# CITY OF ALBUQUERQUE

RE: **Jiffy Lube Expansion**  
**8305-8313 Menaul NE**  
**Grading Plan Stamp Date: 7/23/19**  
**Drainage Report Stamp Date: 7/23/19**  
**Hydrology File: H15D068**

Based on the submittal received on 7/24/19, this project cannot be approved for Plat or Site Plan until the following are corrected:

ENGINEER'S SEAL	<b>JIFFY LUBE MENAU AND WYOMING</b> <b>DEVELOPED DRAINAGE PLAN</b>  <b>TERRA WEST, LLC</b> 5571 MIDWAY PARK PLACE NE ALBUQUERQUE, NM 87109 (505) 858-3100 www.tierrawestllc.com	DRAWN BY RS
			DATE 9/3/2019
			SHEET # <b>D2</b>
			JOB # 2018016

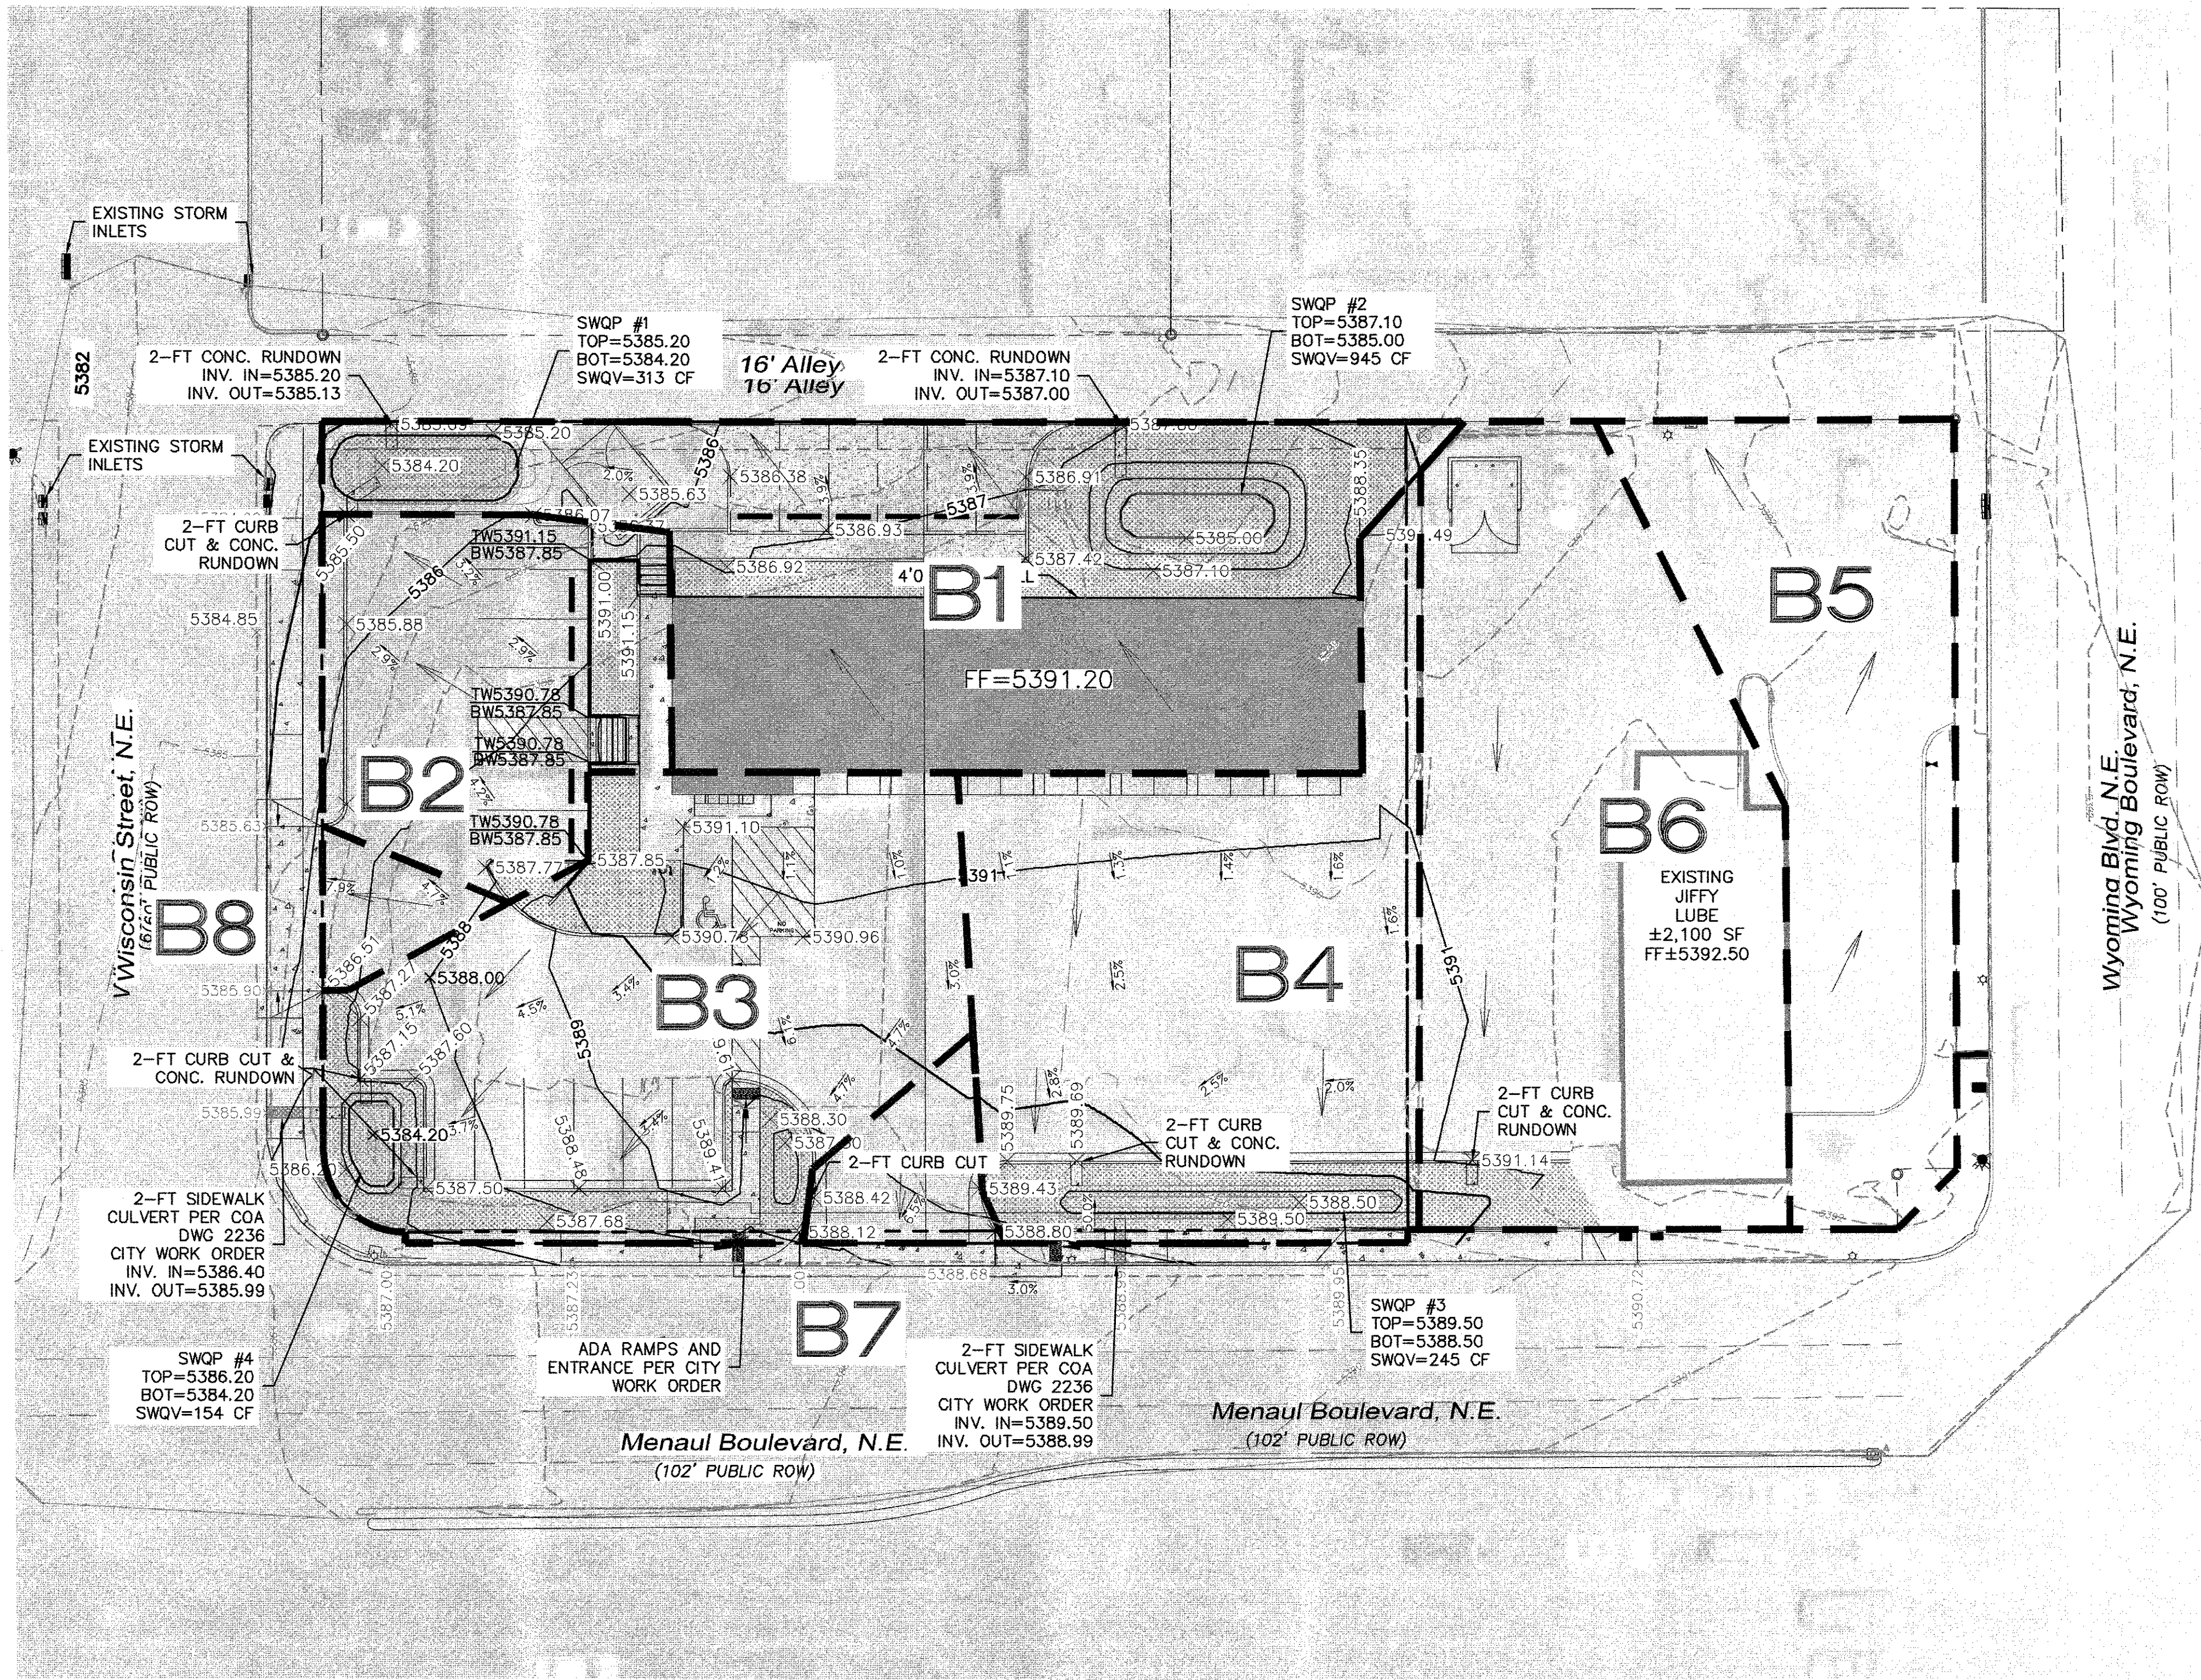
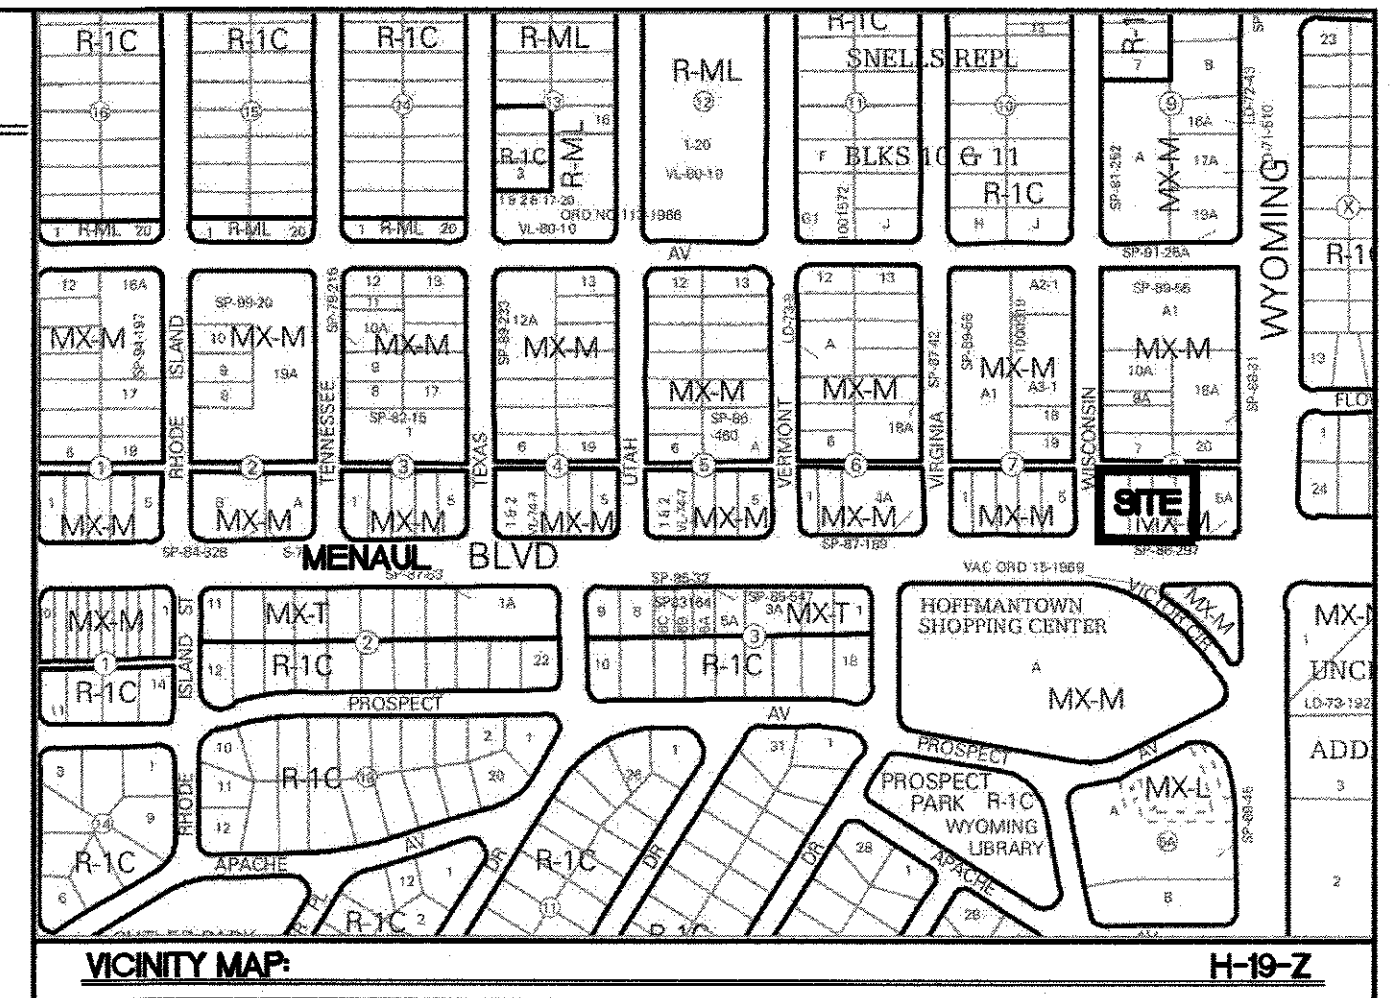
7. Please provide the SWQV calculations for each basin draining to each pond. The stormwater quality ponds need to be sized for the areas draining to them. As currently presented, payment in lieu of some management onsite will be required.
